From: Michaela Briggs <MBriggs1@cityofsydney.nsw.gov.au>
Sent: Monday, 13 March 2017 4:04 PM
To: Andrew Hartcher
Cc: Christopher Corradi
Subject: RE: SSD 7689 & 7561: Walsh Bay Arts Precinct and Sydney Theatre Company

Please find attached report (submission) regarding SSD applications 7689 and 7561 for the Walsh Bay Arts Precinct and Sydney Theatre Company respectively.

The views of the Central Sydney Planning Committee are contained within the report at point 9(a) – (f).

SECTION A

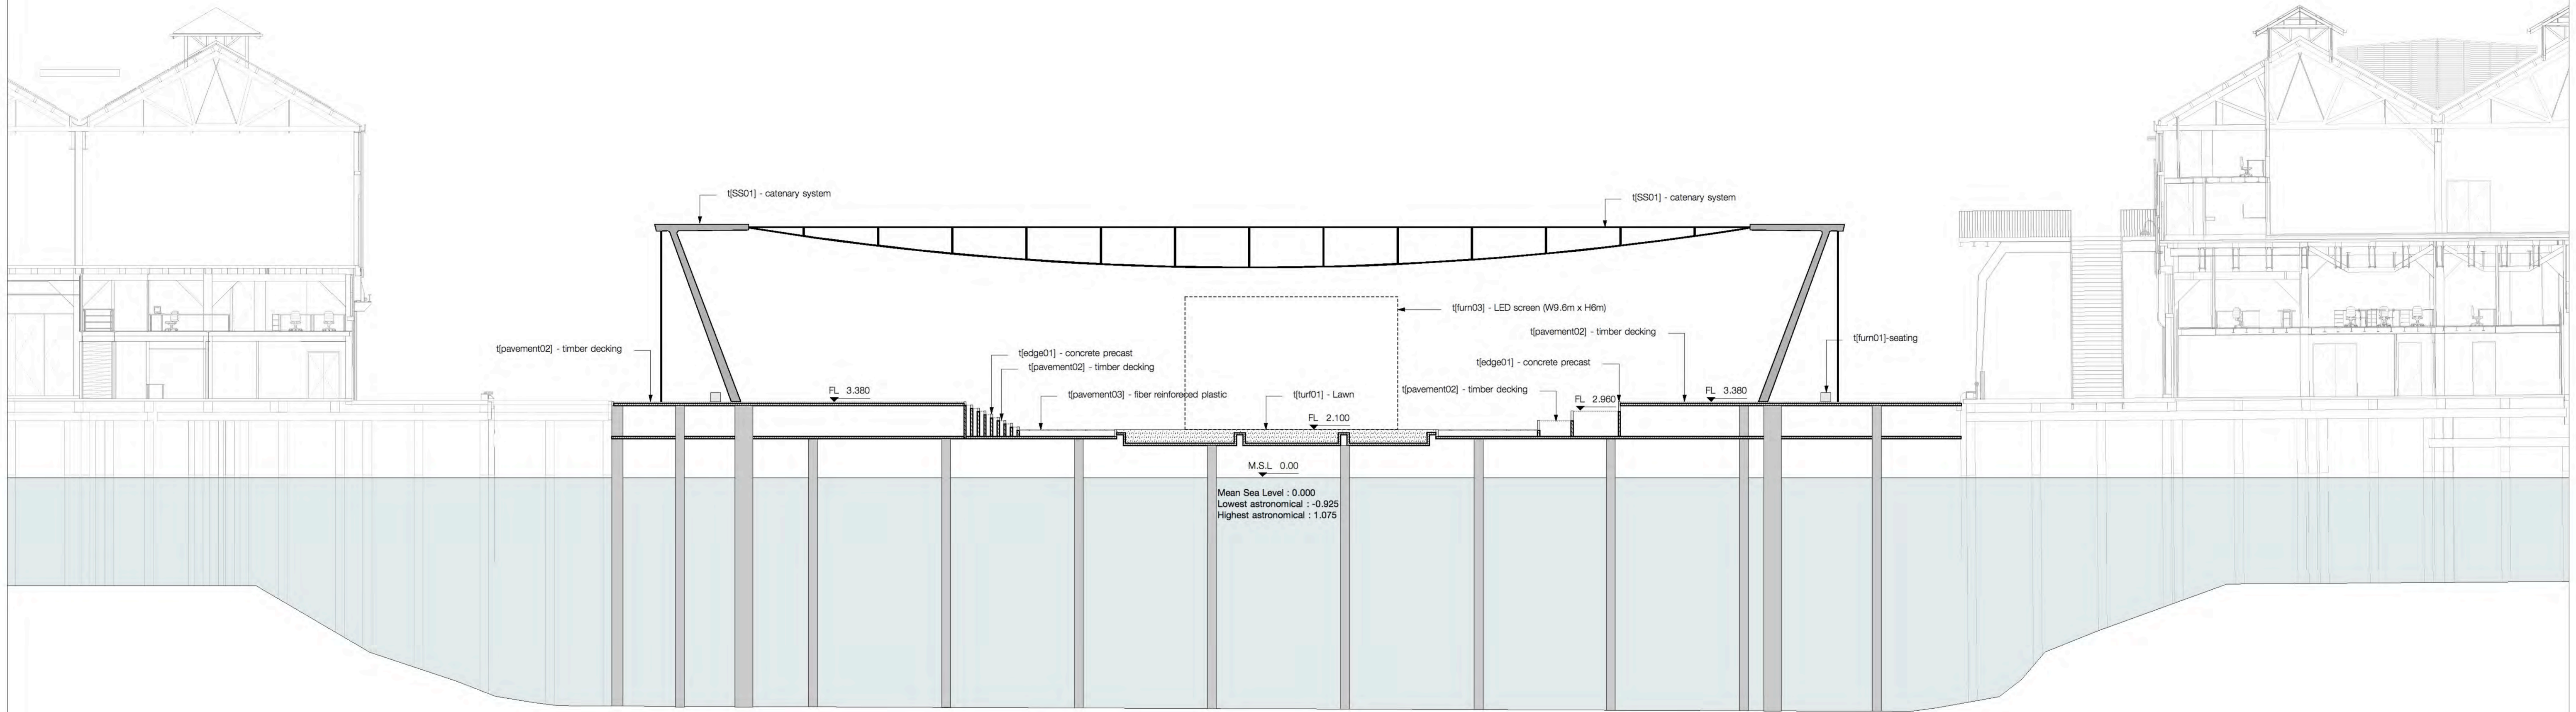
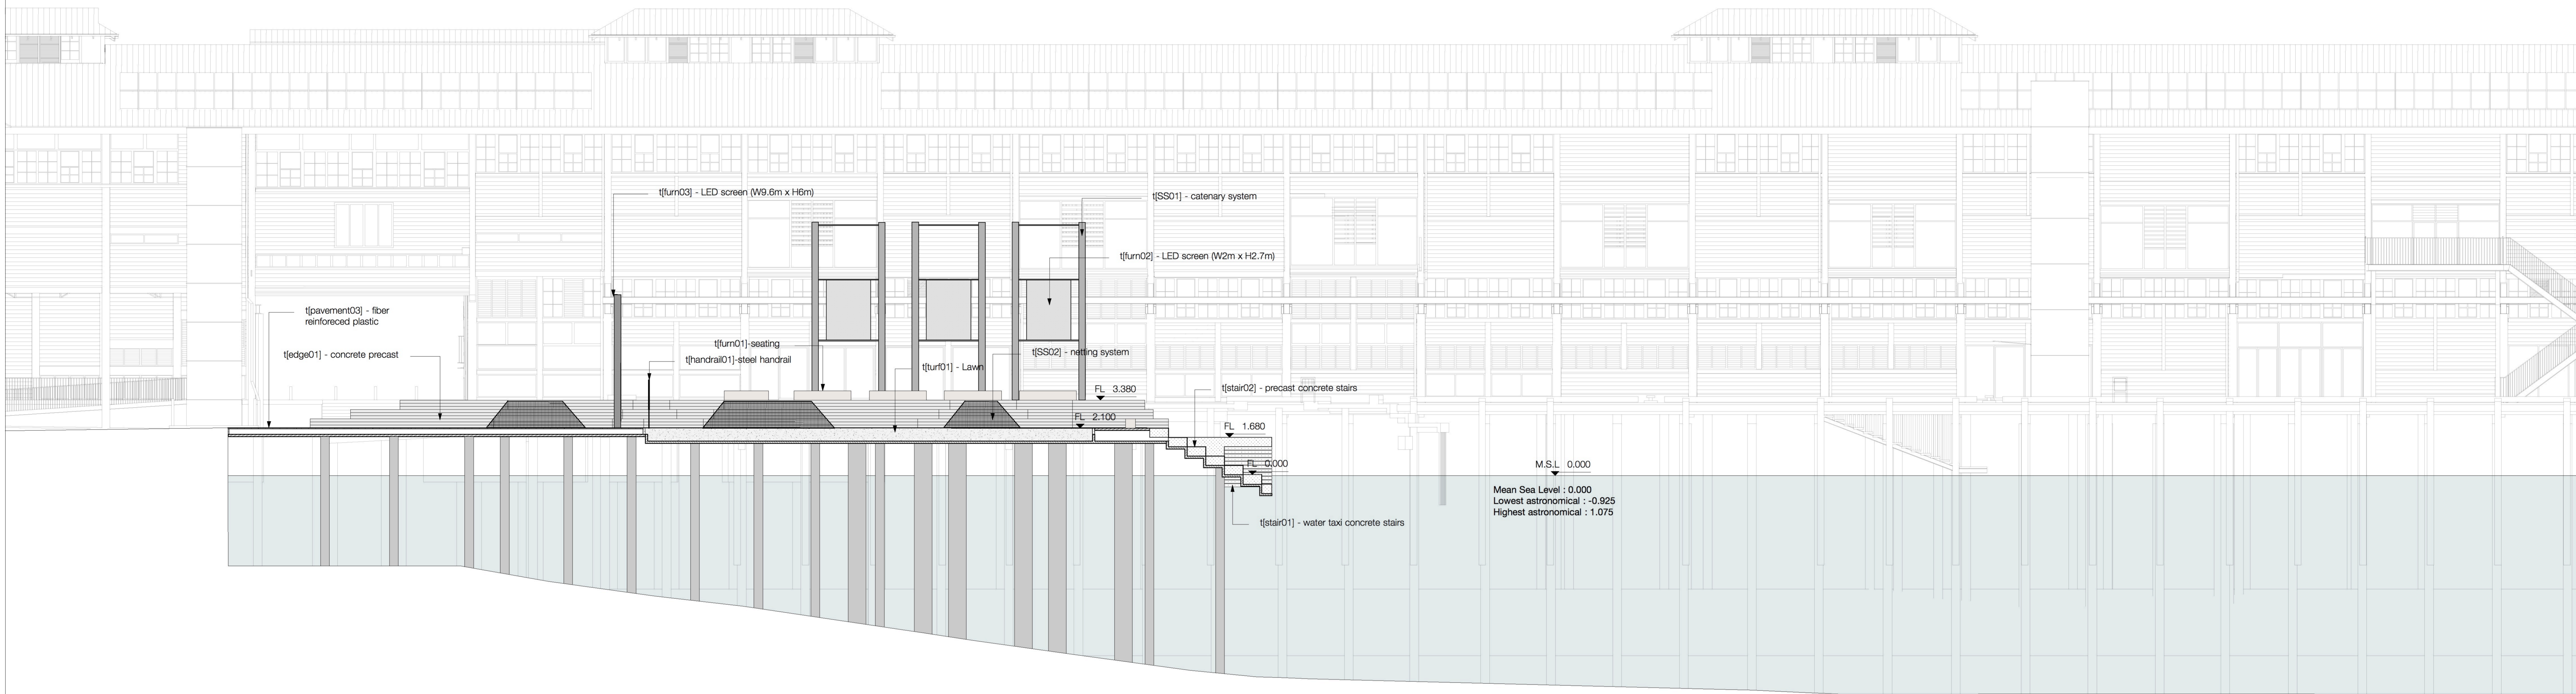
- the deck should clearly be seen as an 'infill', so that there was bridging over water to pass from the existing decks to the new apron. Lightweight decking, netting, subtle levels changes down to the new area and the like could used
- the lawn and concrete deck should be eliminated- the sense of being on an open structure over the water is important
- the new work refer to both the original fabric and the distinguished though understated additions that have been introduced since the 1980's
